Article 21 of the Town and Country Planning (General Development Procedure) Order 1995
Application for approval of details reserved by condition 3 of previously approved planning
application AB/117/12 - construction/operation mechanism and materials of all new joinery
The Old Bakehouse 27 King Street, Arundel,

Arun District Council have decided to **REFUSE details reserved by condition for the following reasons:**

Revisions:	Client:	TUNMORE DESIGN	w: www.ashjoineryttd.co.uk e: www.info@ashjoinery.co.uk t: 01903 776333 f: 01903 776234
	Project:	27 KING STREET, ARUNDEL	
	Drawing Title:	CASEMENT WINDOWS	
	Drawing Number:	13/01	
	Scale:	1:1 @ A3	
	Revision:		
	Date:	08/04/13

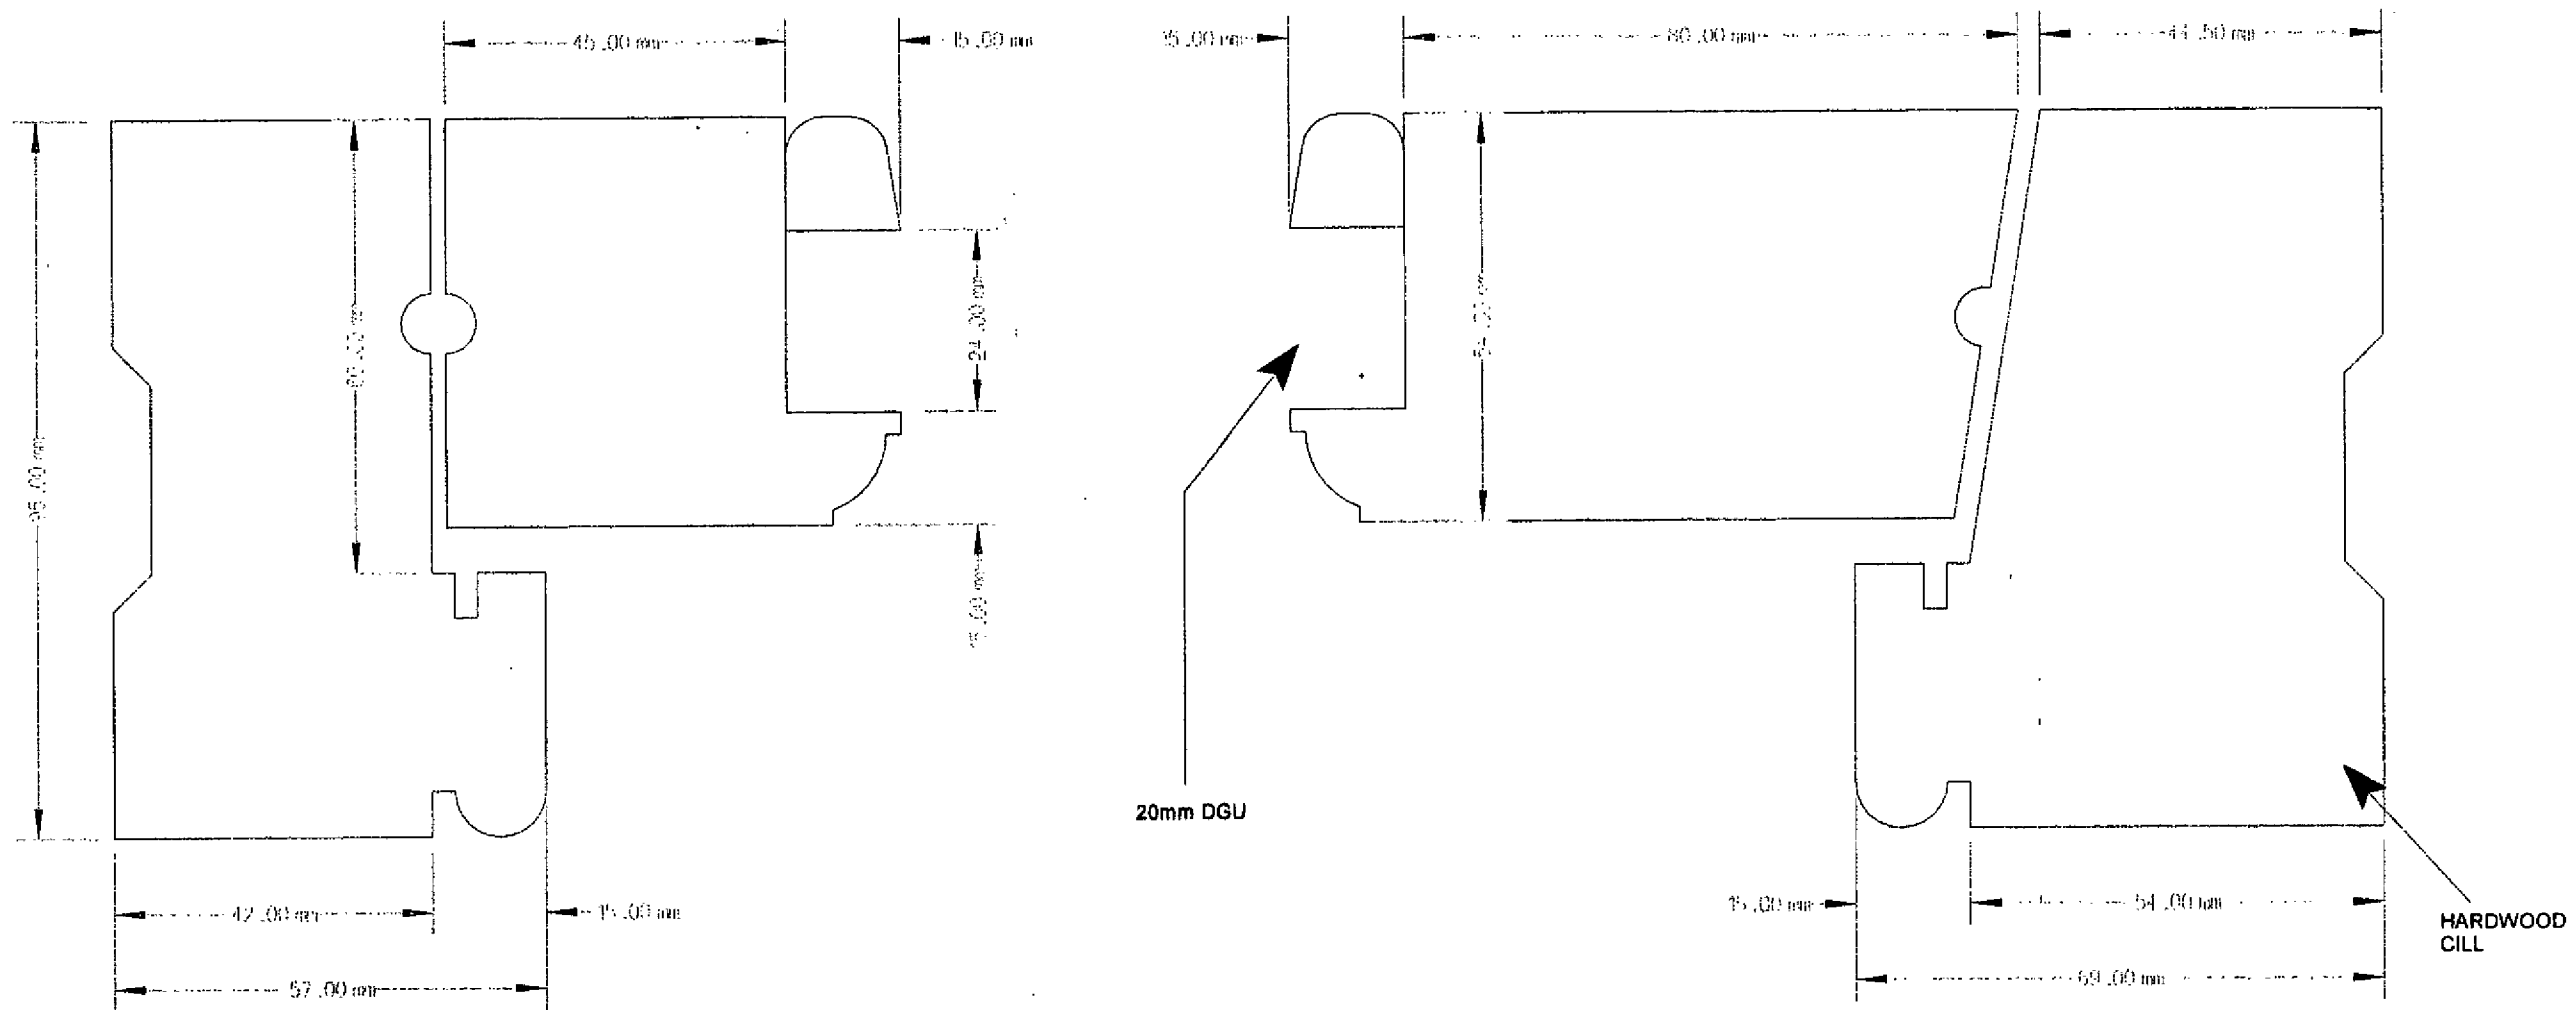
The window details shown on drawing 13/01 are not acceptable for the small window. The beeding is inappropriate. The profile should more closely reflect putty and have a traditional less obvious appearance between the glazing. The details may be acceptable for the doors, but this is not specified and there are no mechanism details included with the application.
